Recommendation Report for Planning Permission for Works or Extension to a Dwelling

REF NO: FP/100/19/HH

LOCATION: 40 Leverton Avenue
Felpham
PO22 7RA

PROPOSAL: Two storey extension to rear of property and garage to side

CLIENT				
MR & MRS D CUMMINGS				
DRAWING TITLE				
PROPOSED DOUBLE STOREY EXTENSION AT 40 LEVERTON AVE FELPHAM				
CHECKED	DATE	SCALE	DRAWN	
	05-2019	1/100@A3	JGM	
PROJECT / DRAWING NO.				REV
001				0

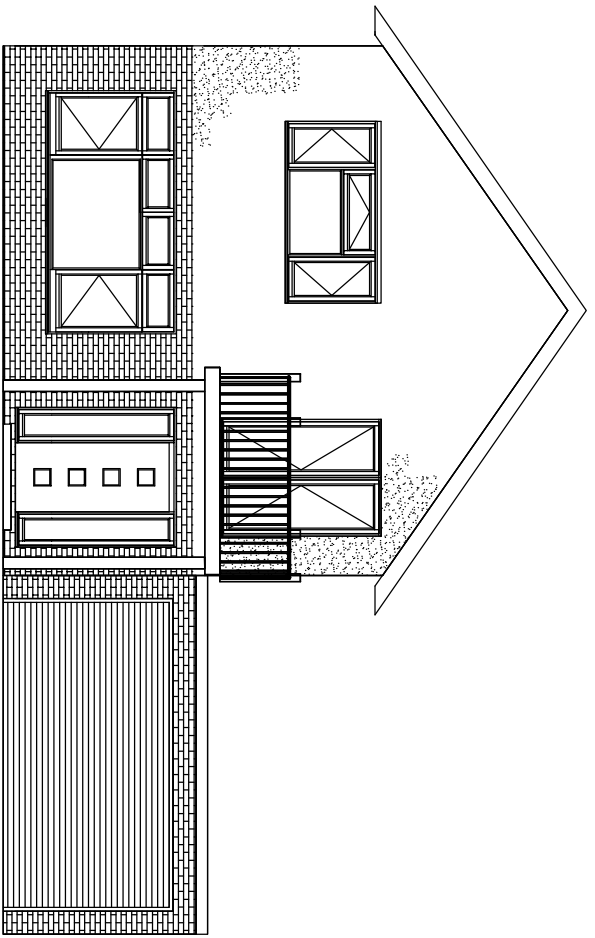
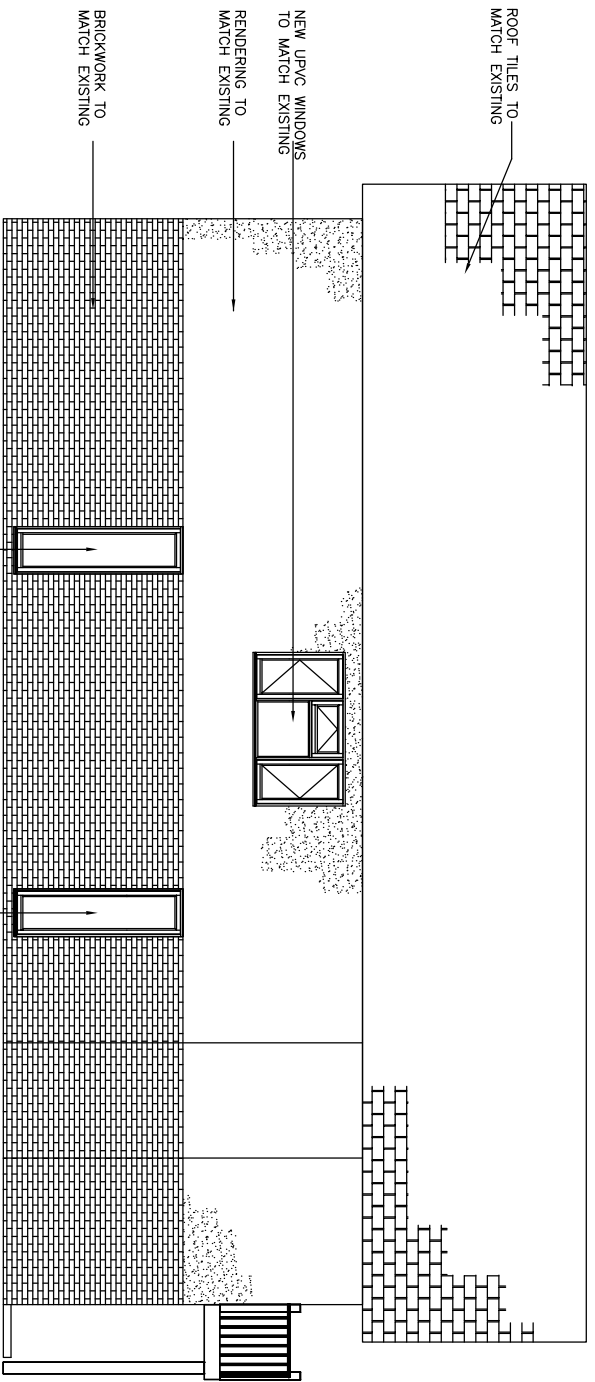
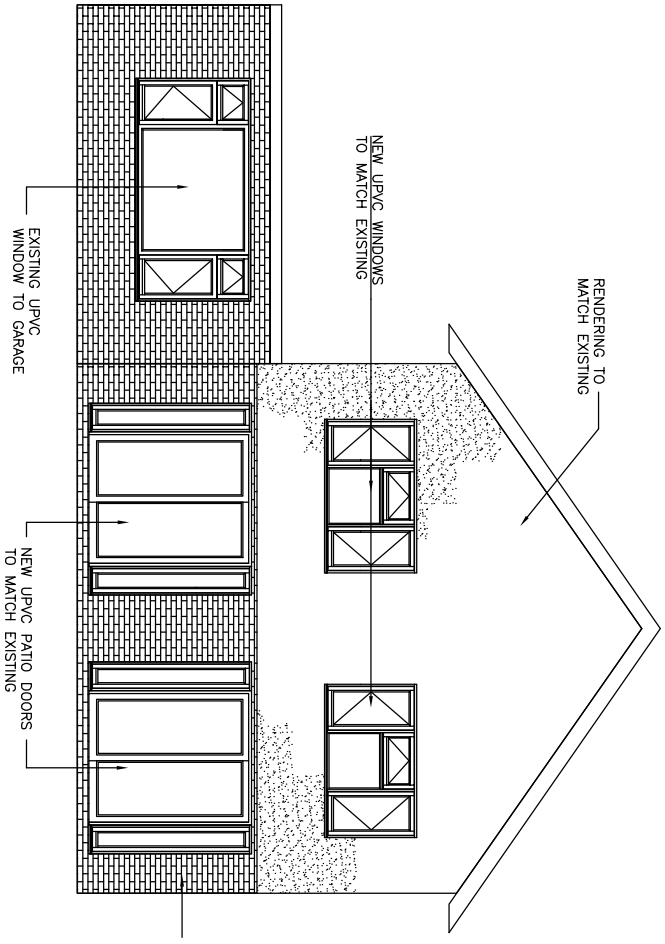
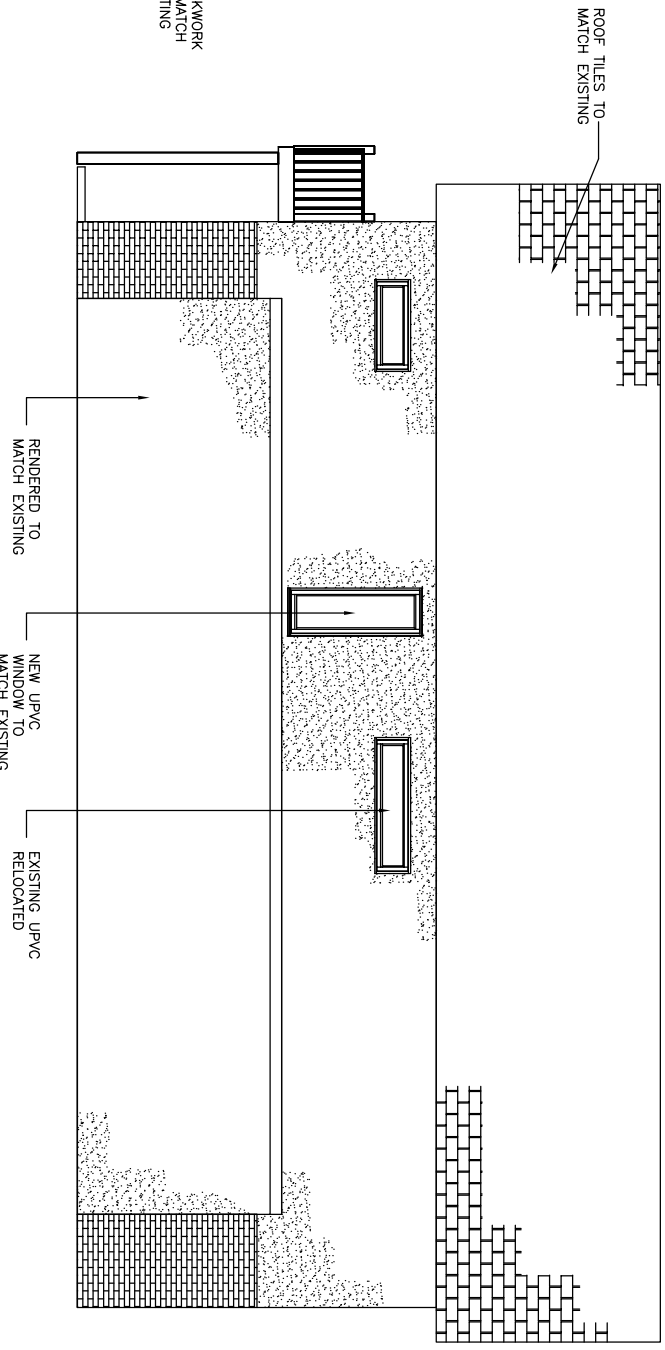
The two storey extension will extend 4.6m. This will match the existing dwelling in height at 7.75m and eaves at 4.75m. This extends only slightly beyond the rear of No.42 and retains 1.4m to the eastern boundary.

The neighbouring property at No.42 has a ground floor window to the western elevation. The development would extend beyond this and therefore may give rise to overshadowing. This is however not considered significant due to the size and siting of the window in such that it is a small high level

window and is not the main window to the room with double doors to the rear. The extension also does not intersect a 45 degree angle when viewed from the centre of the ground floor rear openings.

There will be 2 windows to the rear first floor however these replace existing windows albeit increased in depth. These will not give rise to adverse overlooking with no direct views in neighbouring properties and 16.5m retained to the rear and 4.8m to the west.

There will be 1 additional window to the western elevation at 1st floor level however due to its siting and its purpose in such that it serves a landing it is not considered to give rise to adverse overlooking. There will also be an additional window at first floor to the east serving a bedroom however again due to its siting is not considered to provide adverse overlooking.

PROPOSED GROUND FLOOR

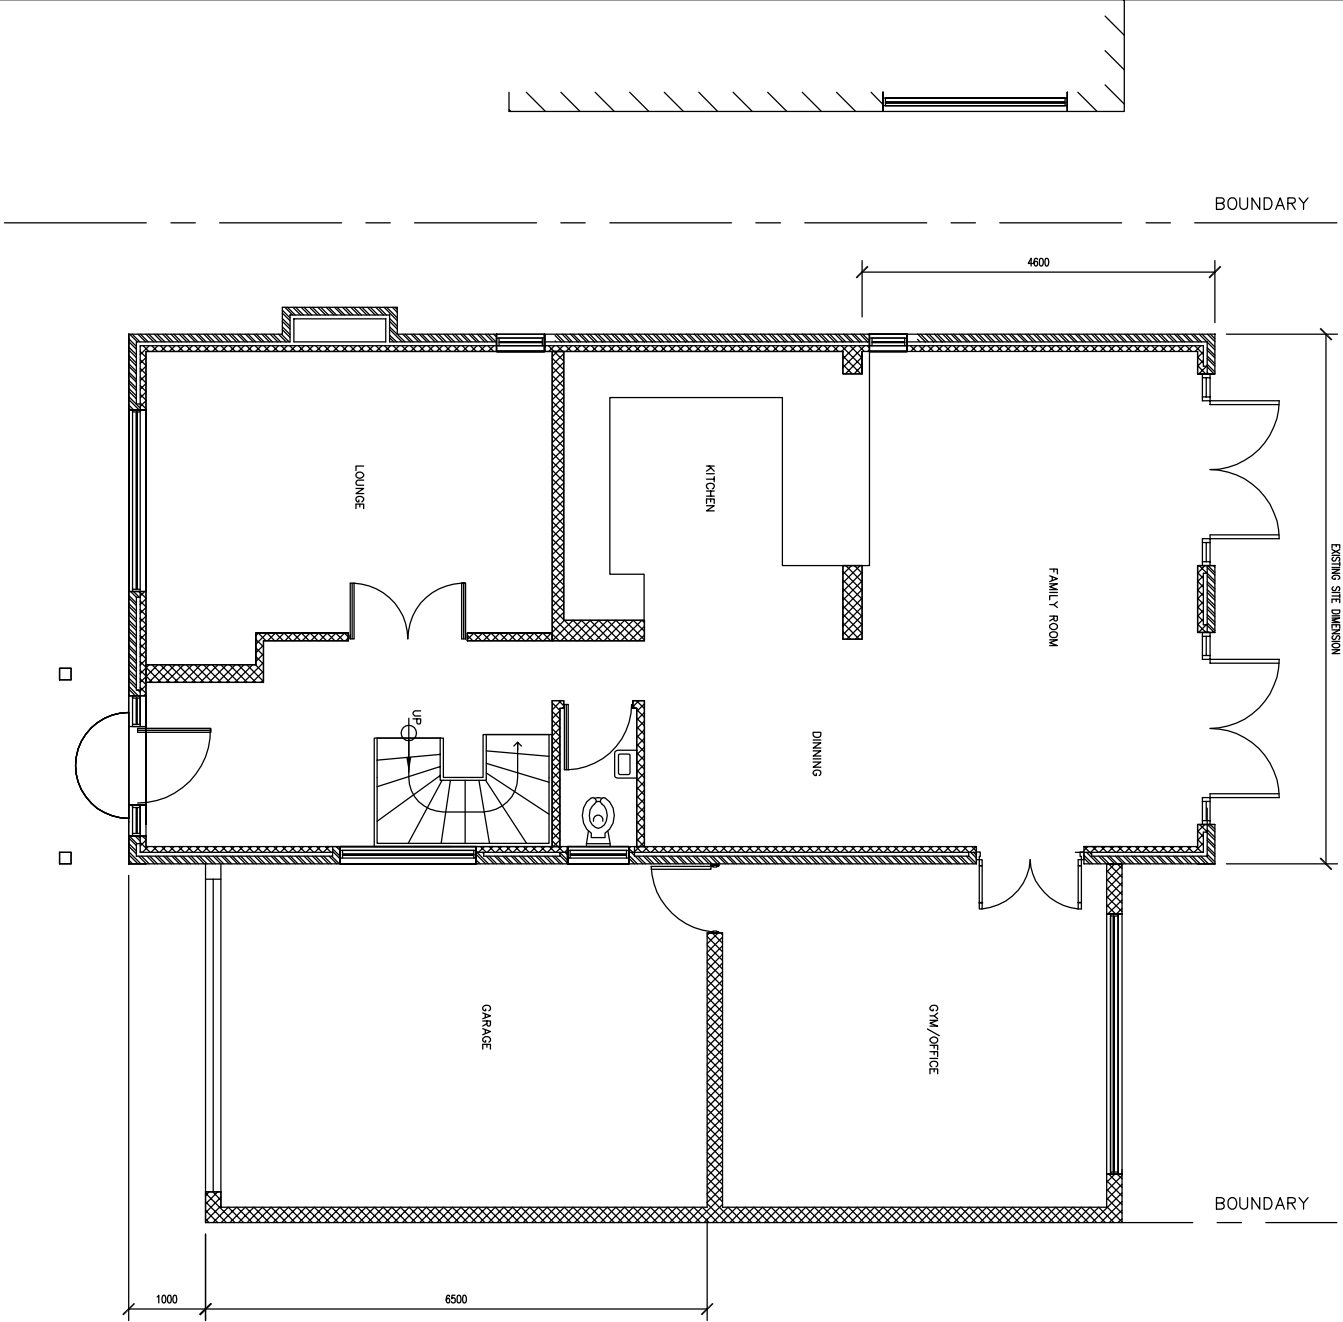
- The garage wall is a party wall and not mentioned on the drawing.
- In front of the garage is a man hole cover which may be covered by the extension and will prevent access.

Comments noted. The party wall is a private matter and the man hole cover will be dealt with under Building Control.
